City of Portland, Maine - Building or Use Permit Application

Permit No: 02-0193	Issue Date:	CBL: 076 A030001
-----------------------	-------------	---------------------

Location of Construction: 1000 Congress St	Owner Name: Gtb Llc	Owner Address: Po Box 4682	Phone:
Business Name:	Contractor Name: Warren Construction	Contractor Address: P.O. Box 362 South Freeport	Phone: 2078653522
Lessee/Buyer's Name	Phone:	Permit Type: Alterations - Commercial	Zoner: IL

Proposed Project Description: Fire escape per Zoning Board of Appeals	Signature: <i>[Signature]</i>	Signature: <i>[Signature]</i>
PEDESTRIAN ACTIVITIES DISTRICT (P.A.D.)		
Action: <input type="checkbox"/> Approved <input type="checkbox"/> Approved w/Conditions <input type="checkbox"/> Denied		
Signature:		Date:

SITE PLAN
1000 CONGRESS STREET
CITY OF PORTLAND, COUNTY OF CUMBERLAND
STATE OF MAINE
BY
RYVAL LOBSTER CO. INC.

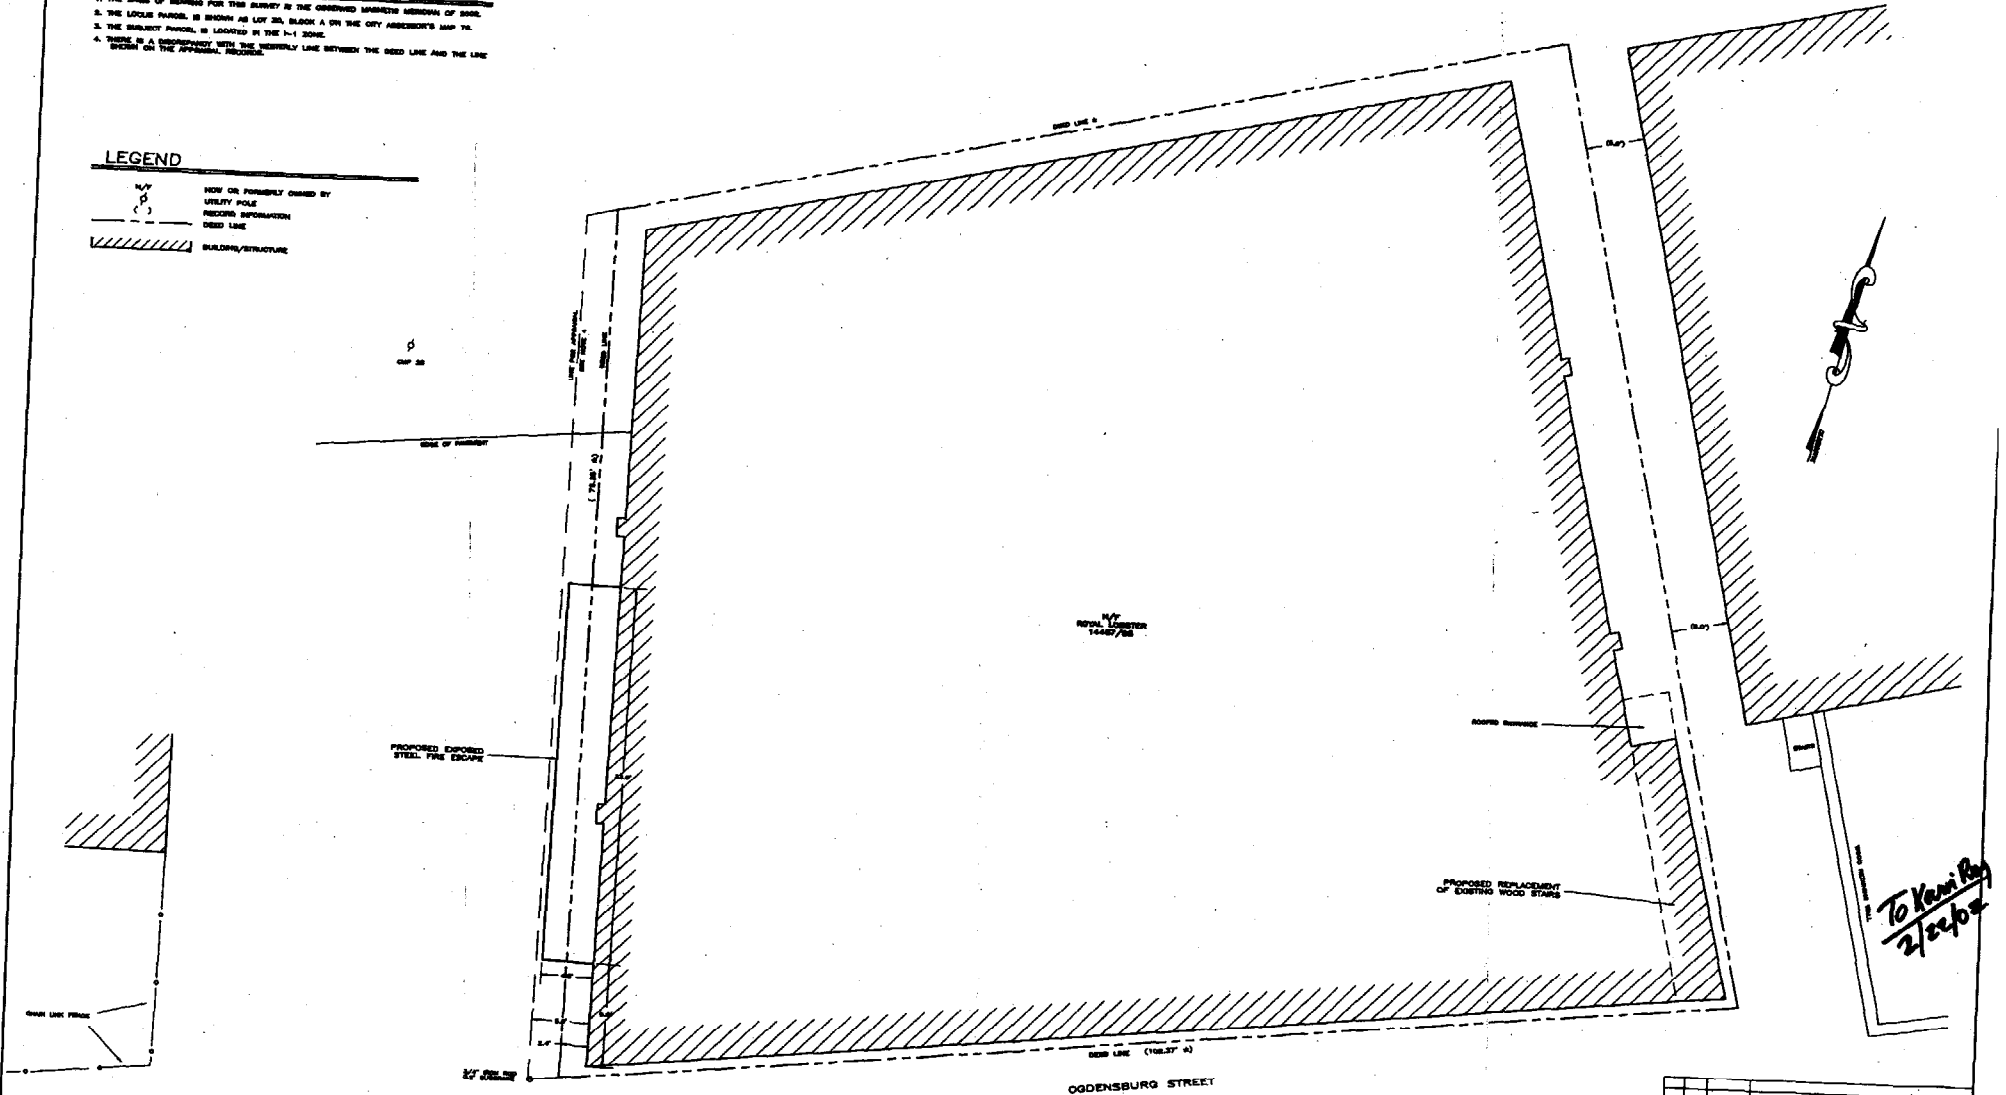
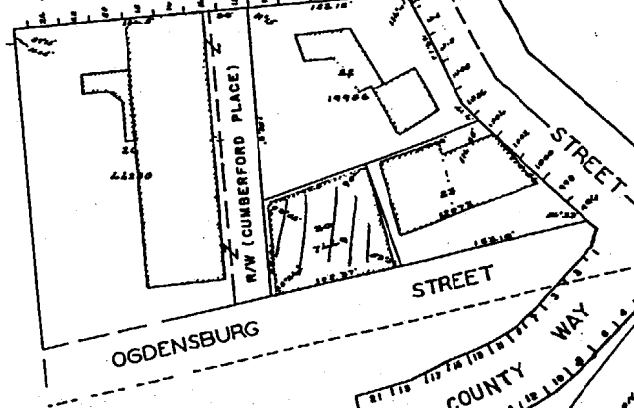
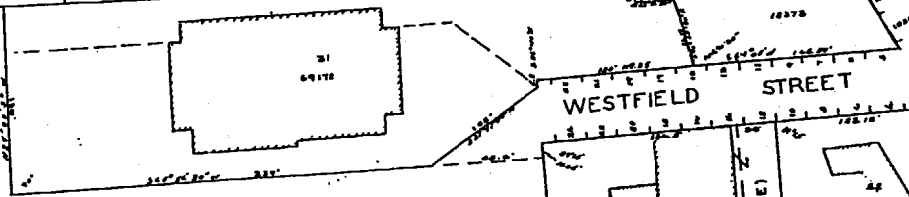
Guards must be 42" w/ openings less than 21" (use group F)

Guards and handrails shall be installed in accordance with NFPA 101
